EL PASO COUNTY

DEPARTMENT OF PARKS AND COMMUNITY SERVICES

**Subject: Sterling Ranch Filing No. 5 PUD Development Plan and Preliminary Plan Amendment, 2nd Submittal
– Final Comments (PUDSP-24-002)**

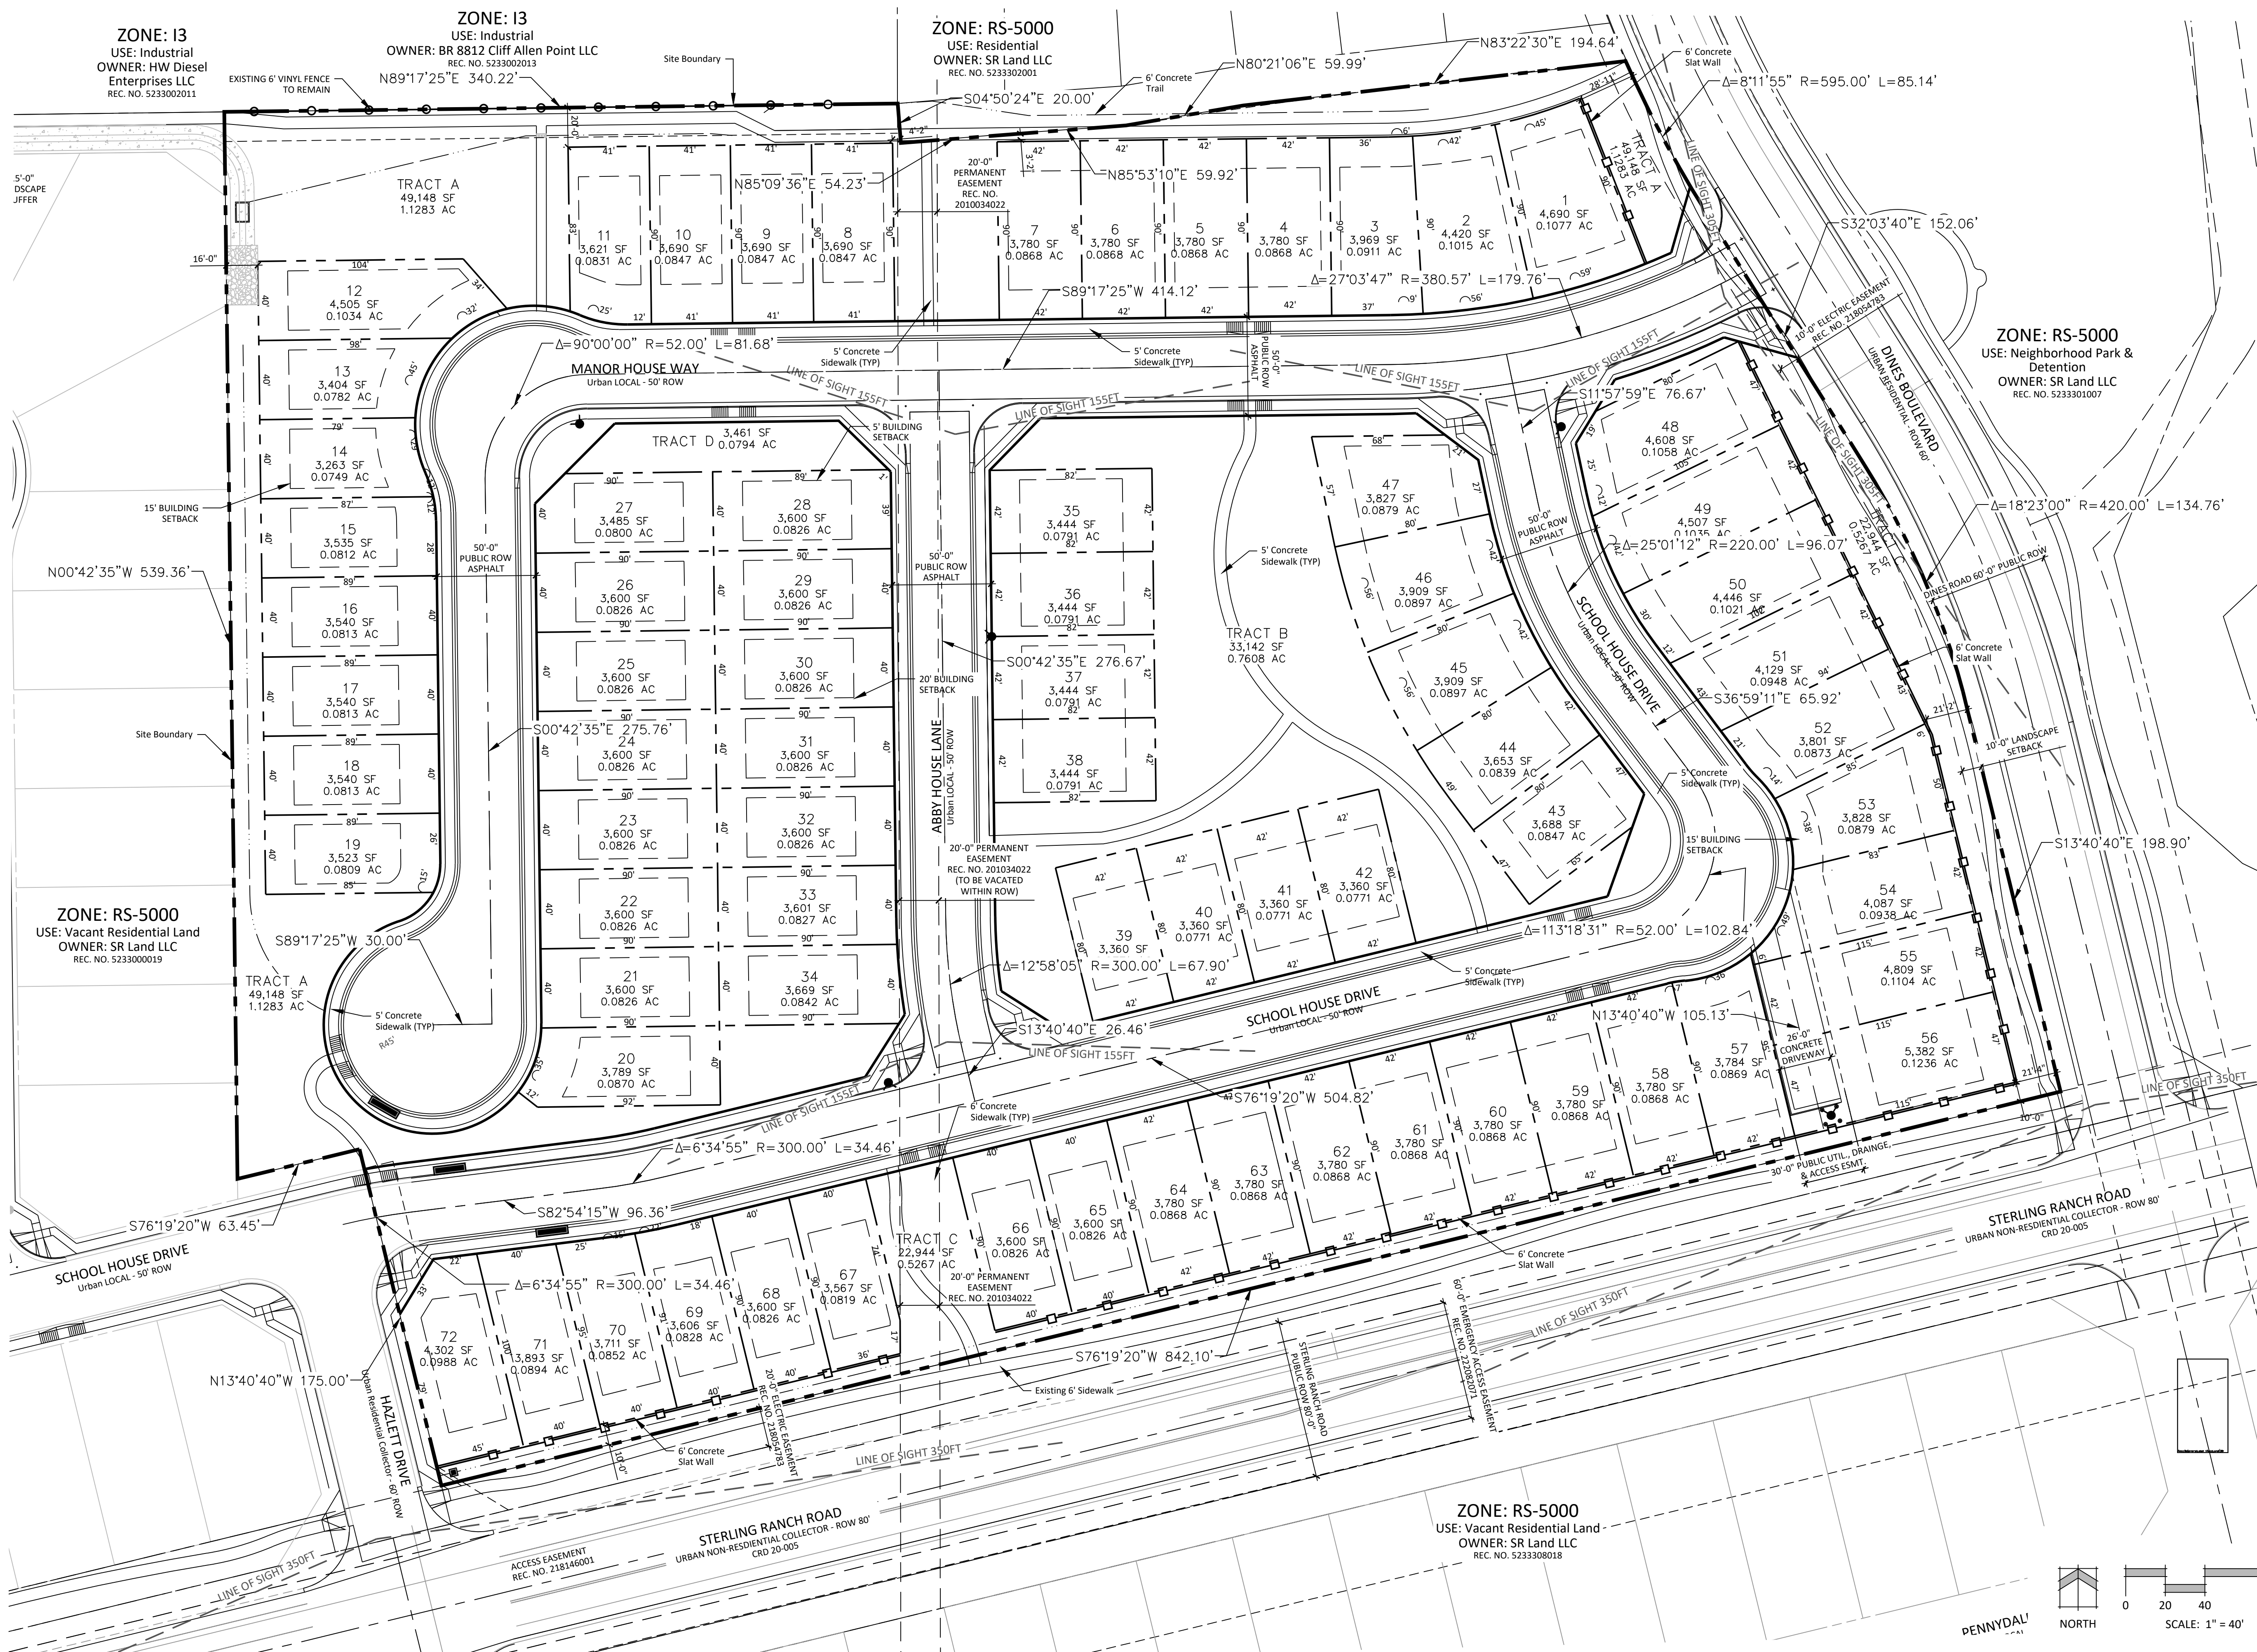
Staff acknowledges the very slight decrease in the open space area, impacting primarily Tract B, which is the location for the centrally-located neighborhood park. An increase in area for Lots 39-42 resulted in a decrease in the size of Tract B by 849 square feet, or 2.5%. This neighborhood park is currently under the provisions of an Urban Park Lands Agreement, approved by the El Paso County Board of County Commissioners on April 10, 2024. Staff discussed this minor impact to the park area and the reduction in irrigated sod estimates and determined that due to the 9:1 urban park improvement to Urban Park Fee ratio, this reduction is not a concern at this time. As such, we encourage the applicant to move forward with the Preliminary Plan amendment and subsequently, the park improvements. However, we caution future impacts to park and open space areas that fall under Urban or Regional Park Lands Agreements, as major changes will necessitate a reconsideration or amendment to the Agreement.
